From: Martyn White
Sent: 20 July 2011 16:35
To: Planning.Responses
Subject: RE: Planning Consultation on: EP/58/11/

APPLICATION NO: EP/58/11/

Registered: 15-JUN-11
Site Address: North end of The Ridings & Angmering Lane & east end of Tamarisk Way East Preston

Description of Works: Replace 3 no. existing estate entrance gates (this application fall within the parish of Rustington)

Drawing No.

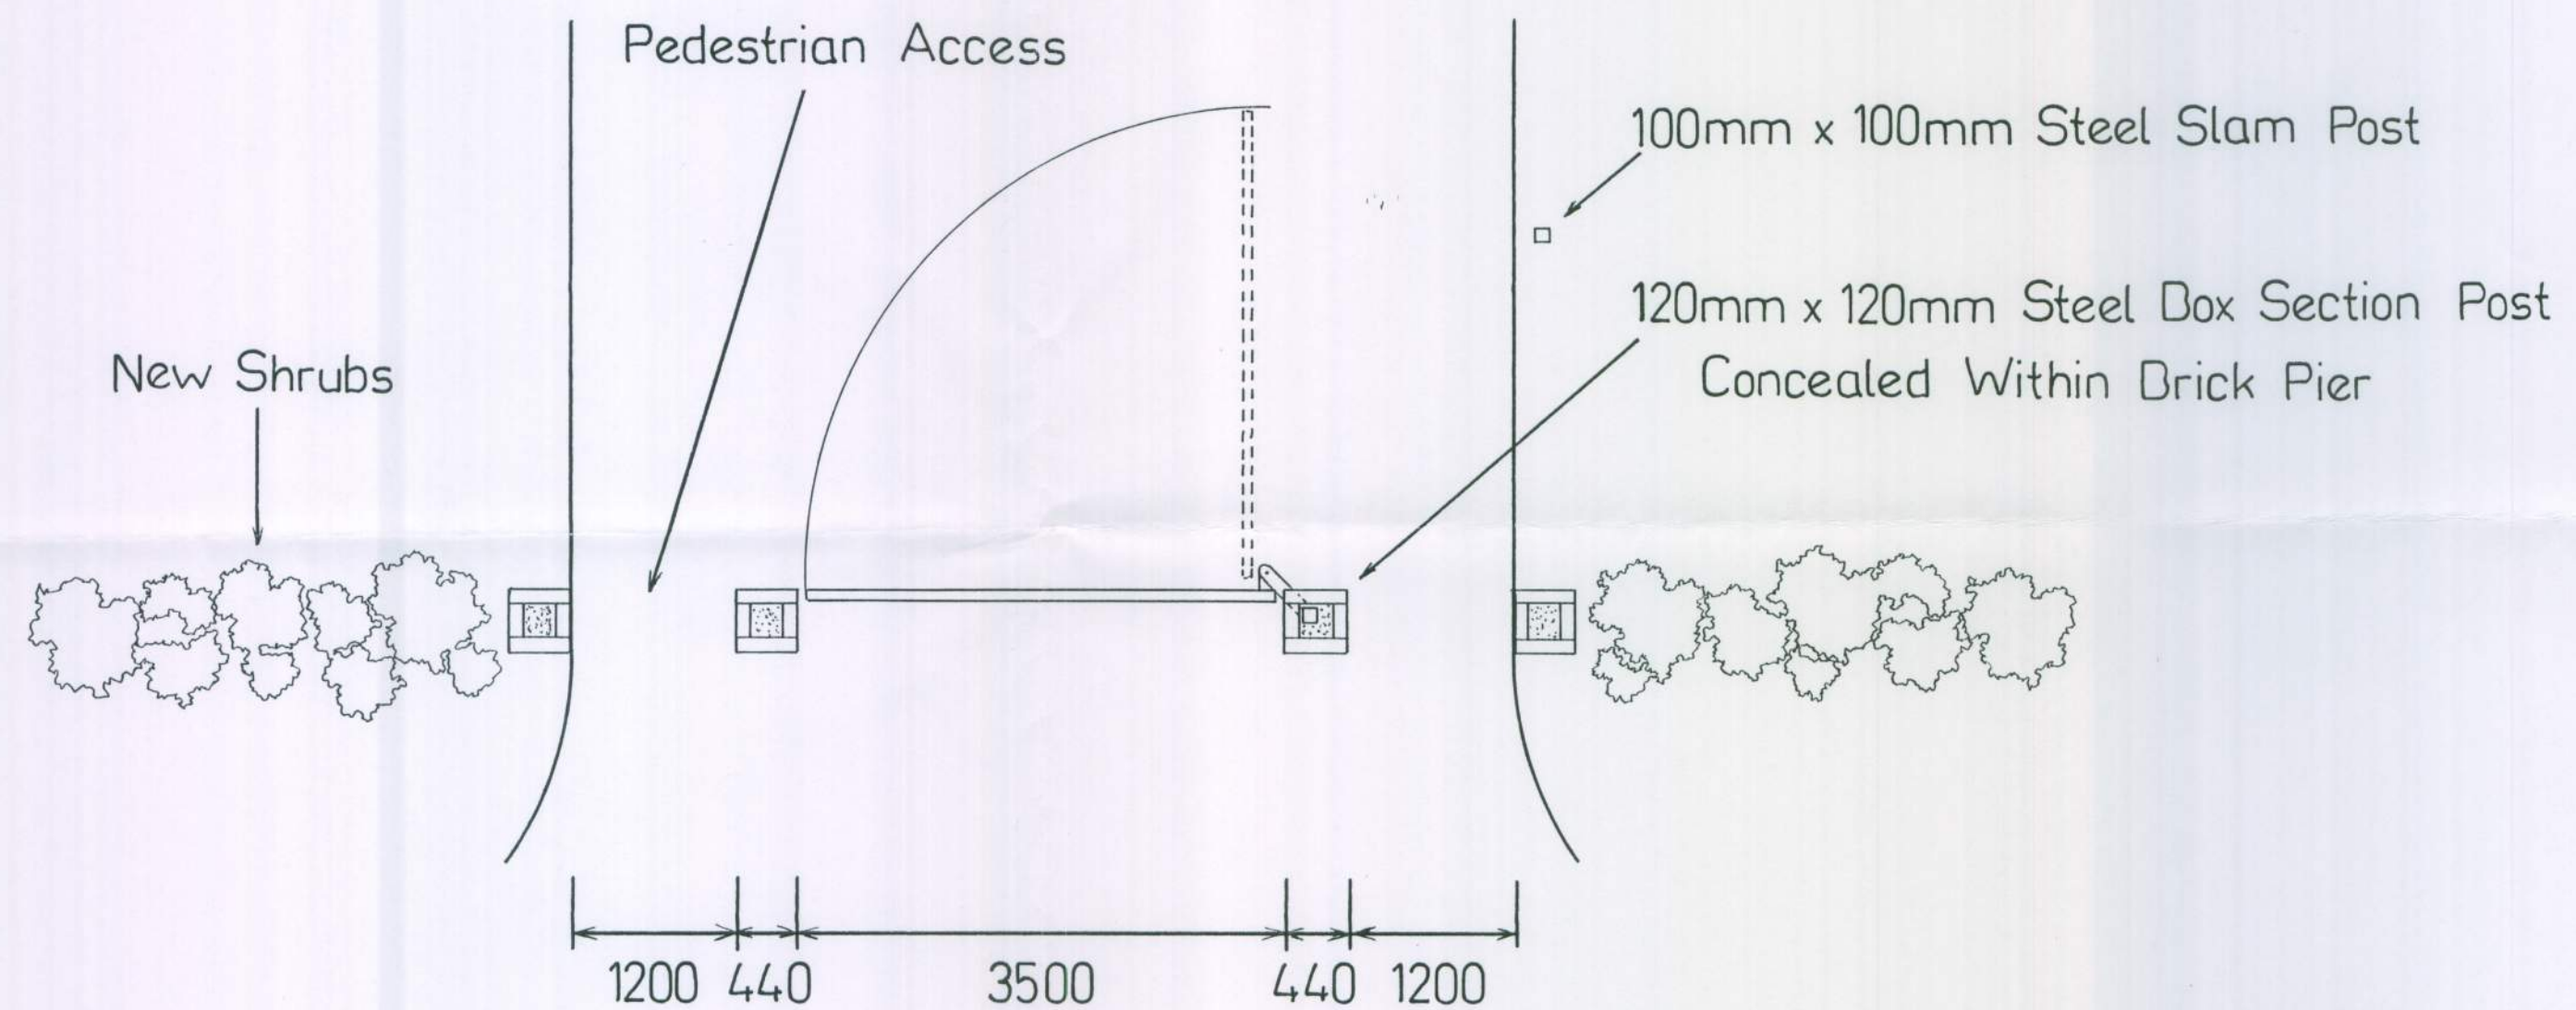
The design of the existing barriers is such that their impact on the locality is minimal. Whereas the proposed wall and gates are much more suburban in nature and would clearly define the boundary between the estate and the road network. Consequently, it is considered that the proposal would form a feature that would conflict with its locality.
